Our Ref: EN010128

Application by Cory Environmental Holdings Limited for an Order Granting Development Consent for the Cory Decarbonisation Project

Notice by Applicant of Intention to Submit a Request for Proposed Changes to the Development Consent Order (DCO) Application

Proposed Change

DRAWING TITLE:
**PROPOSED JETTY
INDICATIVE DRAWING
REGULATION 5(2)(o)
APPLICATION DOCUMENT
REFERENCE 2.12**

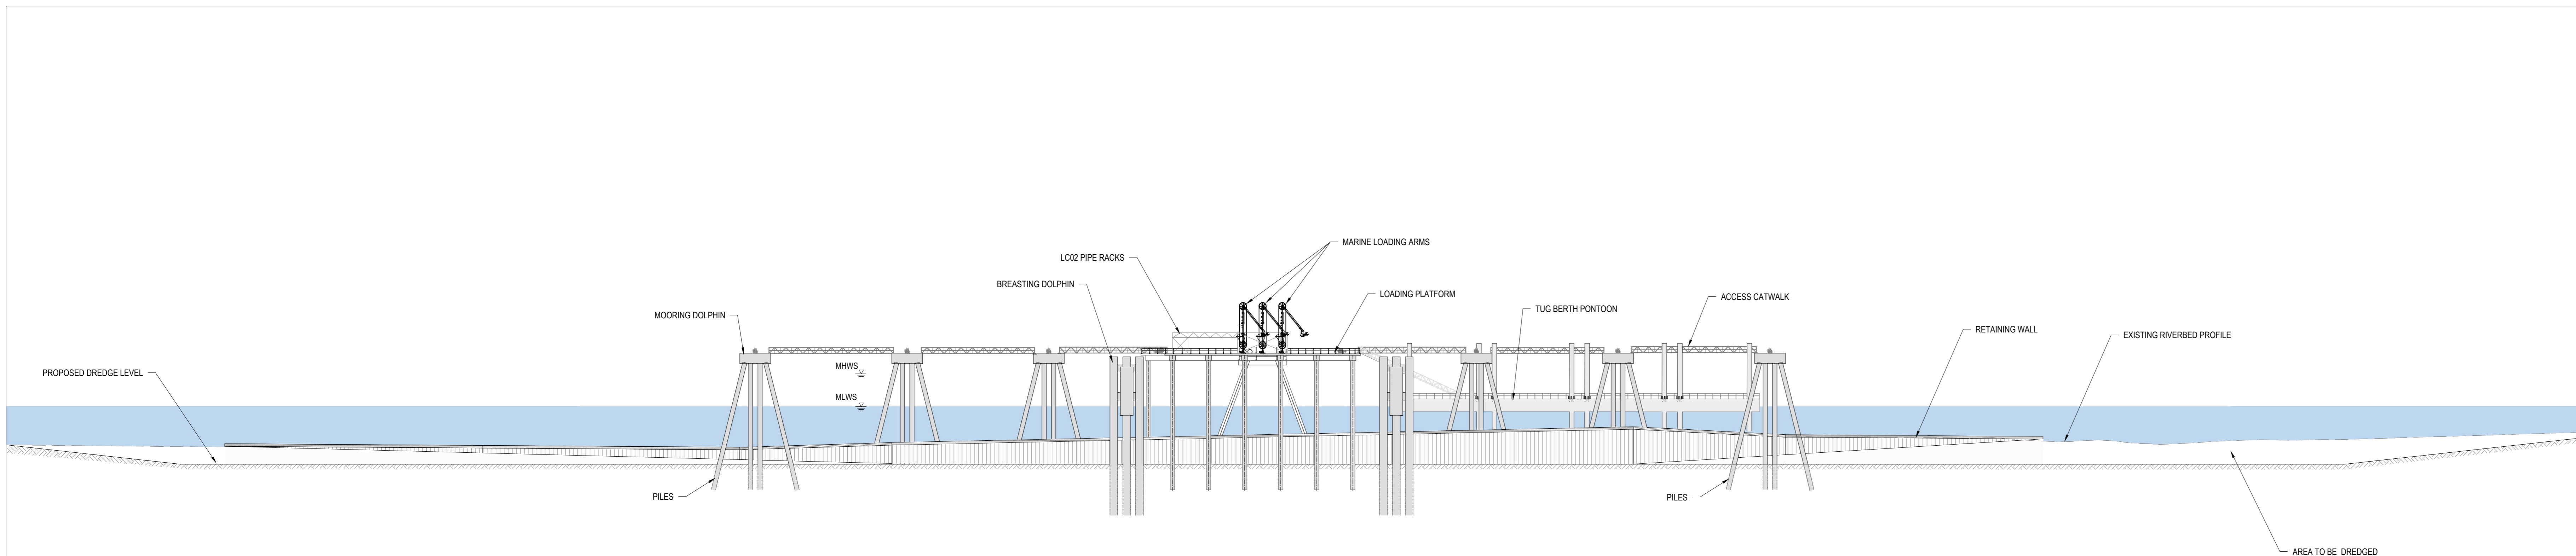
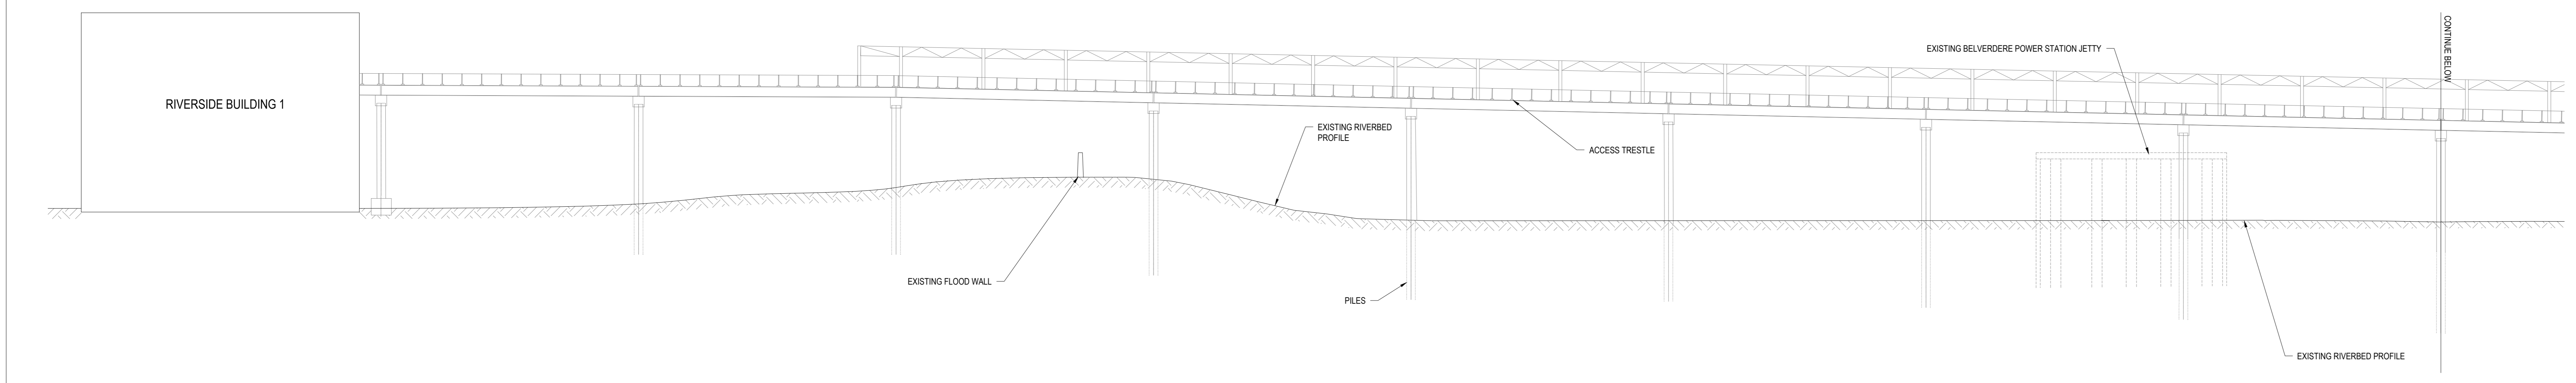
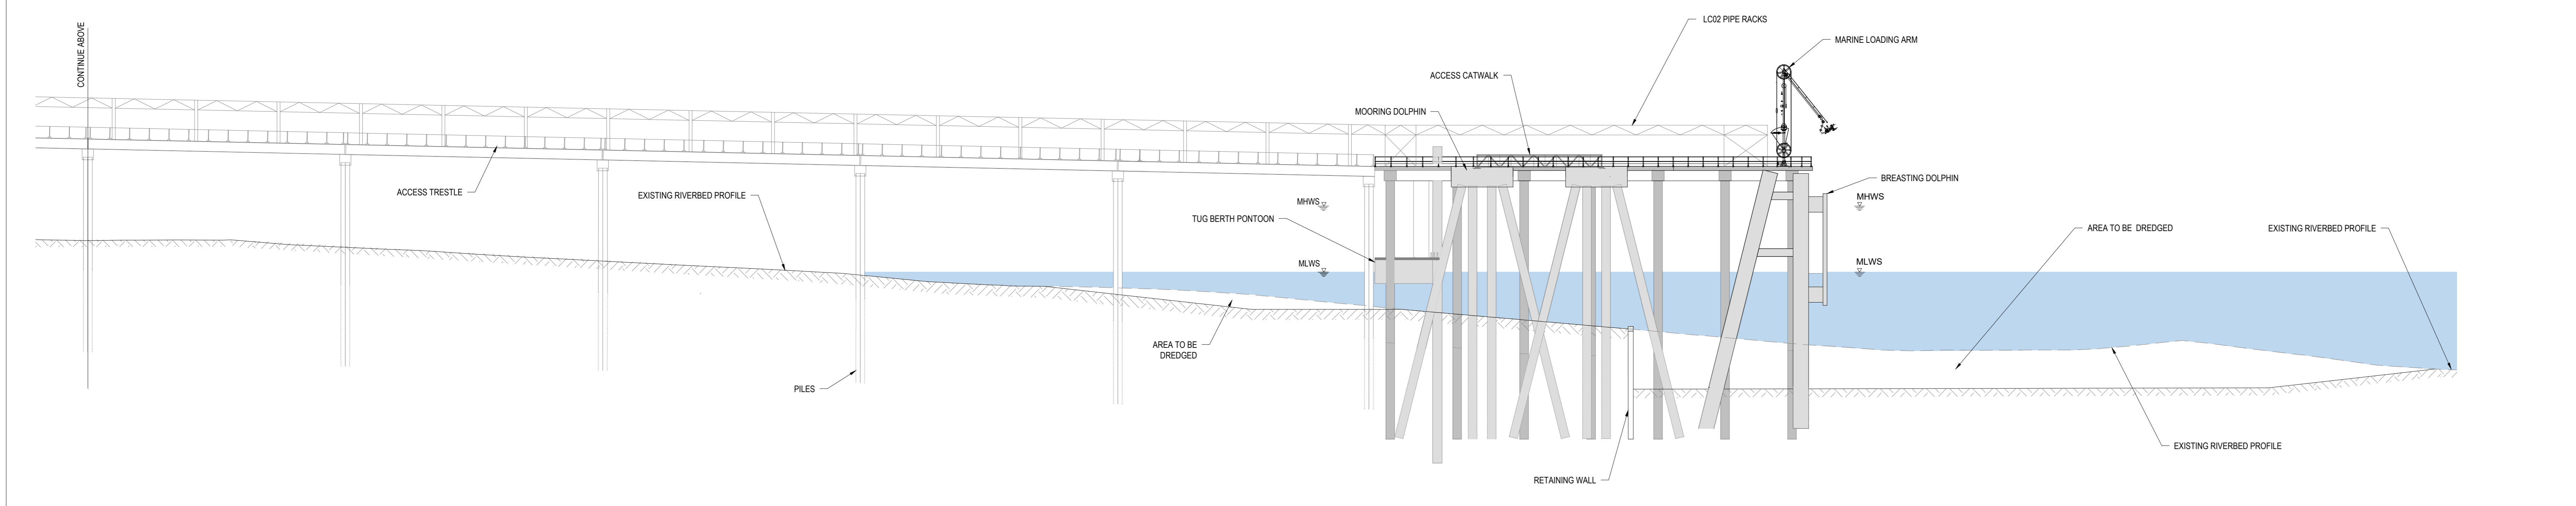
The ExA notes the proposed change includes revising the design of the Proposed Jetty, and associated dredging, to facilitate a maximum vessel size of approximately 20,000m³, rather than the maximum 15,000m³ currently anticipated in the application documentation. This would entail:

- an increase in assumed capital dredging volume by approximately 40,000m³ to account for small changes in jetty design, which, although not a secured number, would need to be considered from an assessment perspective;
- a likely increase of the size of the sheet pile retaining wall either side of the dredge pocket by a combined approximately 70m, which, although not a secured parameter, would need to be considered from an assessment perspective; and
- the downwards limits of deviation for dredging set out in article 2 of the draft DCO being increased from minus 10.50 chart datum to minus 11.00 chart datum.
